**United Utilities Water Limited
Developer Services & Planning**
Warrington North WWTW
Barnard Street off Old Liverpool Road
Gatewarth Industrial Estate
Sankey Bridges
Warrington
WA5 1DS

Your ref: 3/2016/0309
Our ref: DC/16/1614
Date: 26-APR-16

Location: Land adj to 2 Harewood Avenue, Simonstone
Proposal: erection of one new dwelling house

LOCATION & SITE PLAN
OF
LAND AT 2 HAREWOOD AVE
SIMONSTONE
FOR
MR & MRS M LANGLEY

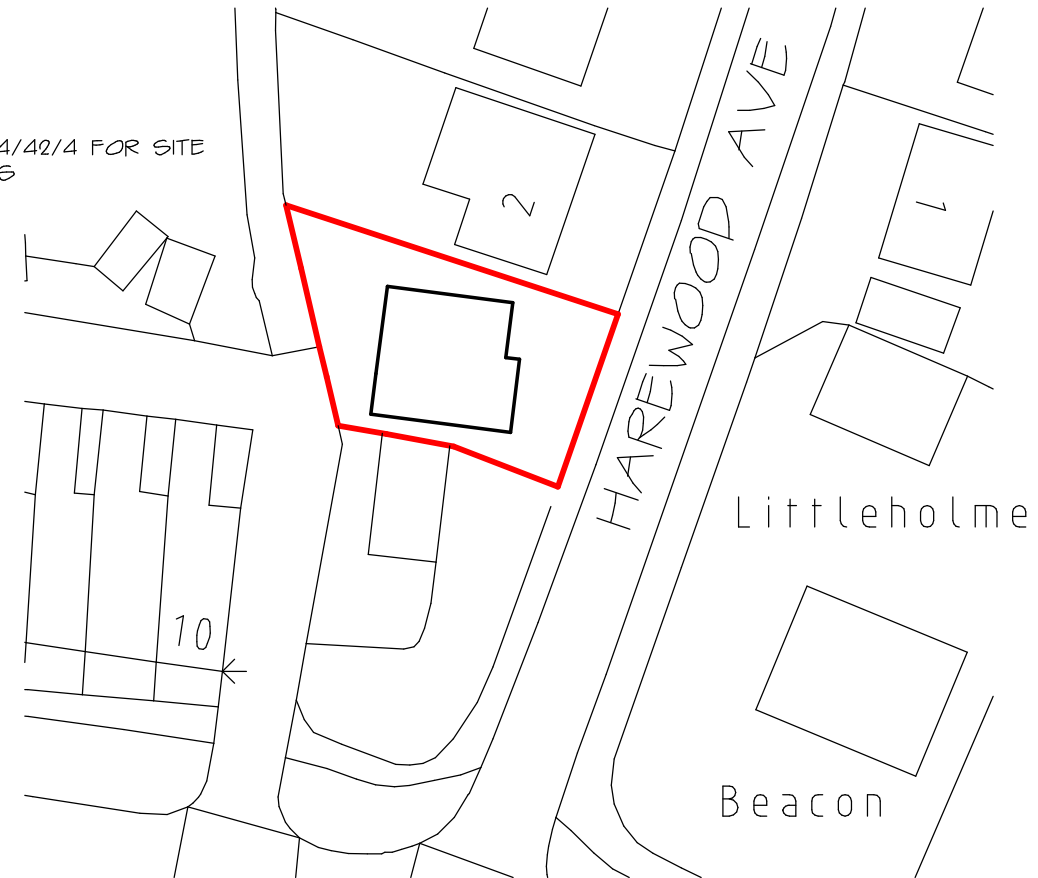
A public sewer crosses this site and we may not permit building over it. We will require an access strip width of six metres, three metres either side of the centre line of the sewer which is in accordance with the minimum distances specified in the current issue of "Sewers for Adoption", for maintenance or replacement.

Deep rooted shrubs and trees shall not be planted within the canopy width (at mature height) of the public sewer and overflow systems. Trees should not be planted directly over sewers or where excavation onto the sewer would require removal of the tree.
